Highways England  
Spatial Planning  
Brunel House  
930 Aztec West  
Bristol  
BS32 4SR

████████████████████  
26 February 2020

### **The Proposed Portishead Branch Line (MetroWest Phase 1) Order – Section 56 Planning Act 2008. Highways England Formal Response**

Figure 8-1: Portishead Construction Compounds

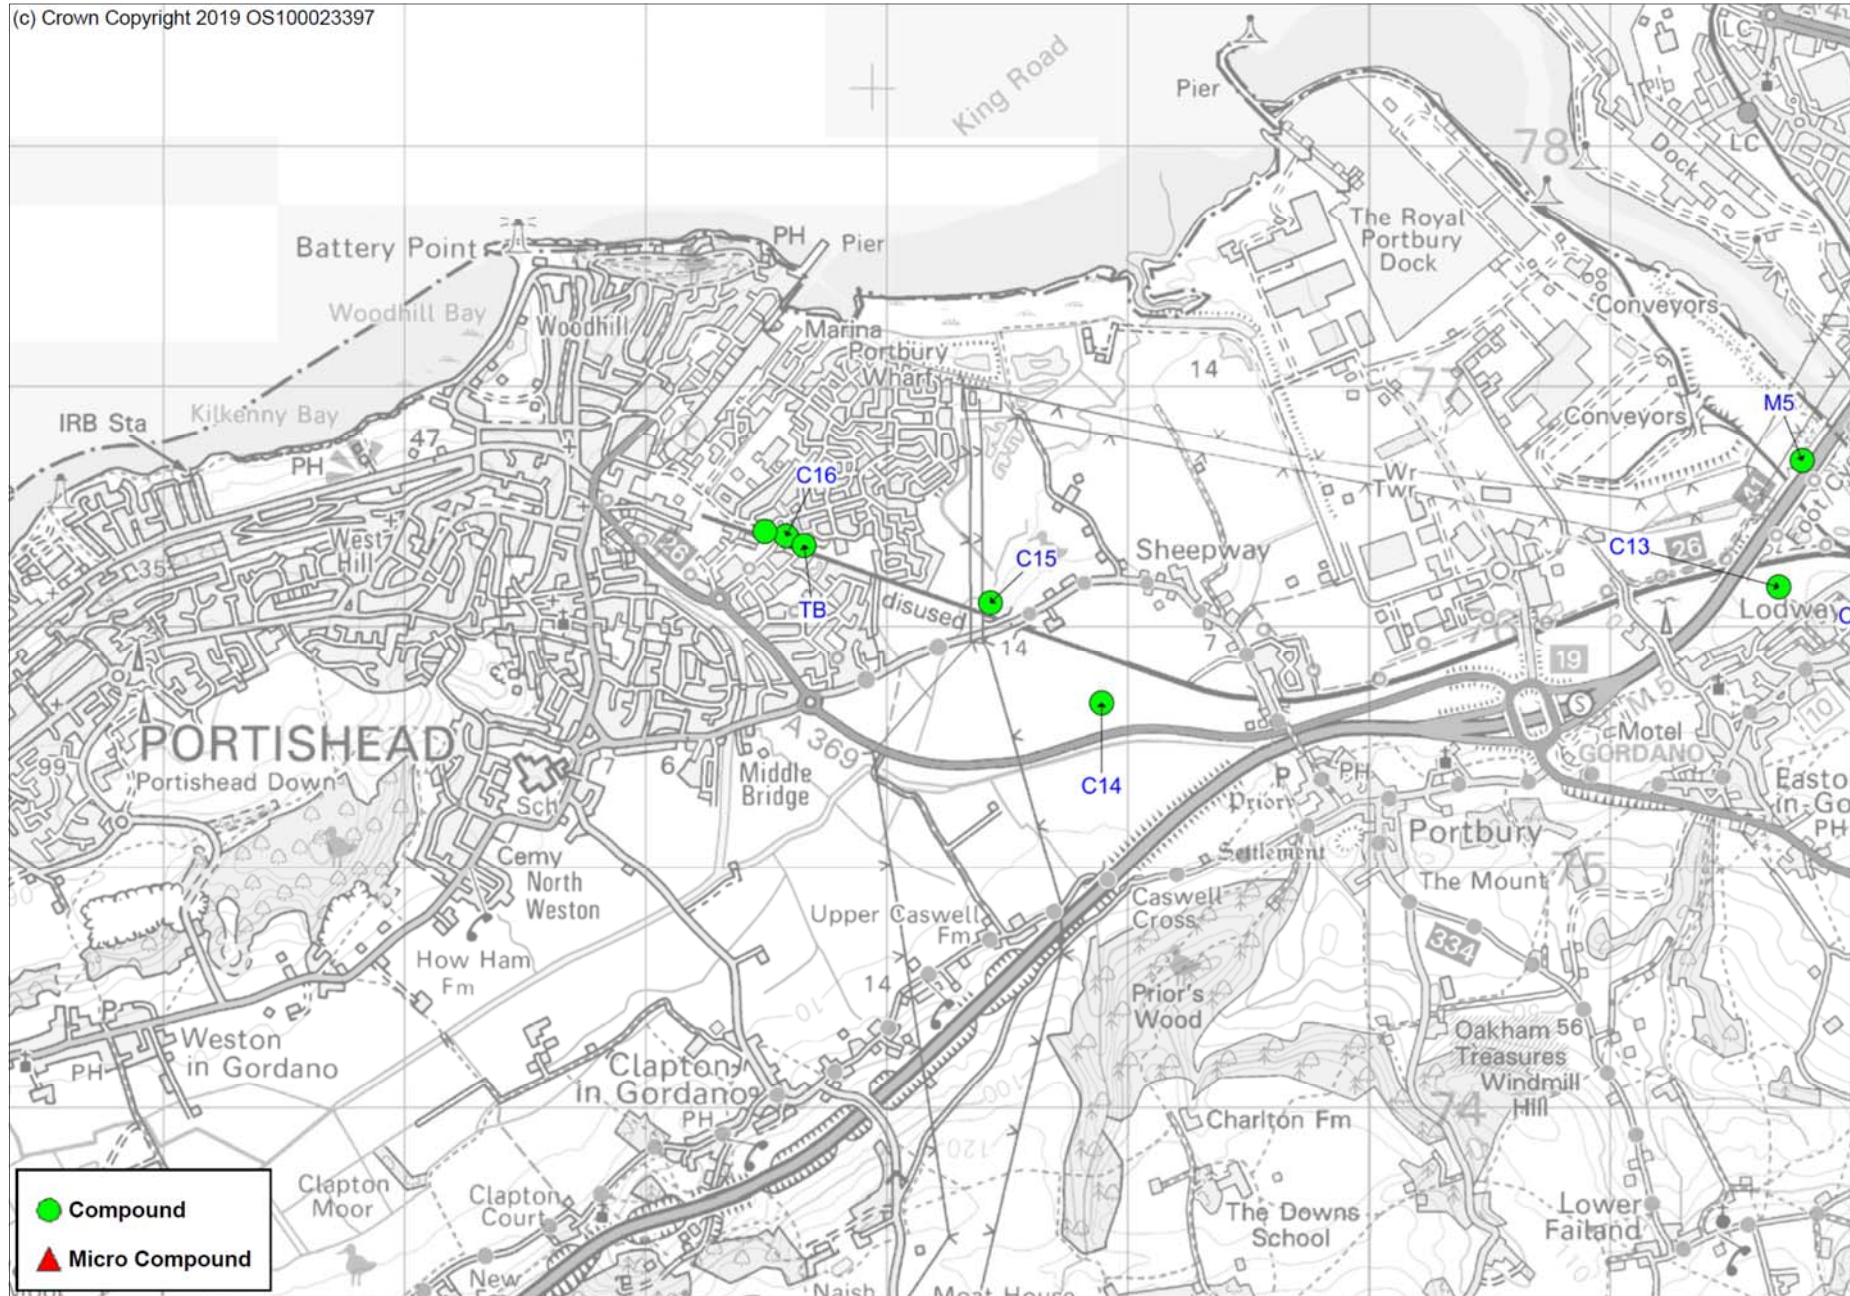
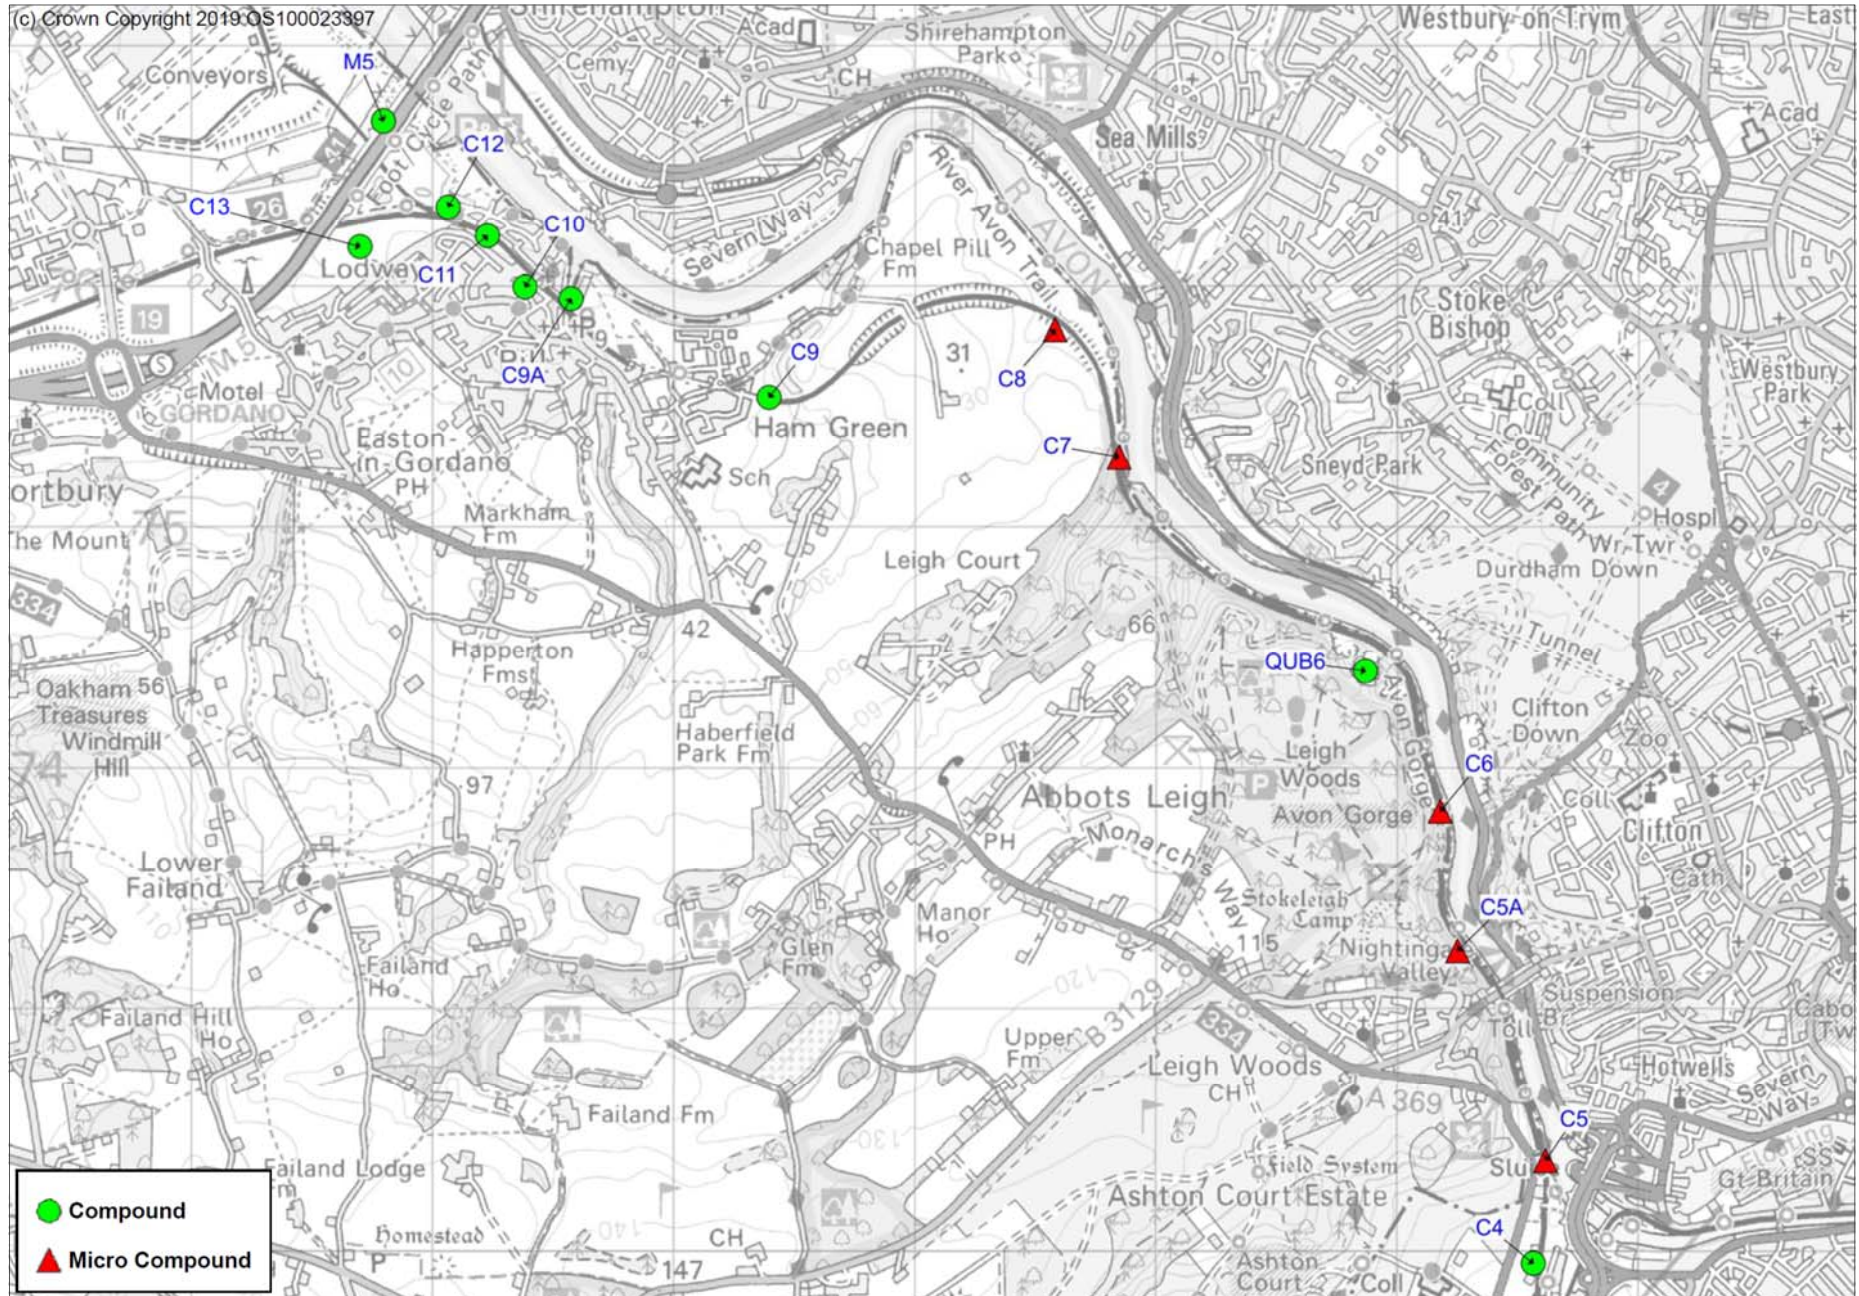
There are some 20 locations described as 'main compounds' and 'satellite and other compounds'. There are 7 main compounds that will be responsible for the shipment of materials and a destination for site workers, and a further 13 satellite locations where site workers will be based. The access routes and facilities at each of these locations is listed in Section 4 of the Outline CTMP.

One of the selected locations proposed for a satellite compound is under the M5 Avonmouth Viaduct. Table 4.1 in the Outline CTMP notes that the location will be used for Rail Road Vehicle (RRV) access and some deliveries. Access will be via Royal Portbury Dock Road and Marsh Lane. Table 4.2 in the Outline CTMP notes that the M5 compound location may be used for car parking, Road Rail Access Point (RRAP), a small storage area and location for a welfare van or small welfare unit. The compound would be required for the duration of the construction works for the import of materials, which may be brought in at night. The use of this location has been discussed with Highways England as part of an ongoing dialogue. We will require this dialogue to continue to ensure that we can maintain the safe operation of the strategic highway above the compound for the duration of its use.

Given the location of the site compounds distributed over the length of the scheme, the Outline CMTP states that, where possible, journeys should seek to avoid residential areas and keep to main roads. Specifically, it is noted that the M5 and M5 J19 should be used to access the compounds and site accesses, to avoid lengthy journeys through urban areas.

Highways England understands this approach, though needs to ensure that the increase of construction traffic does not impact on the safe operation of the SRN.
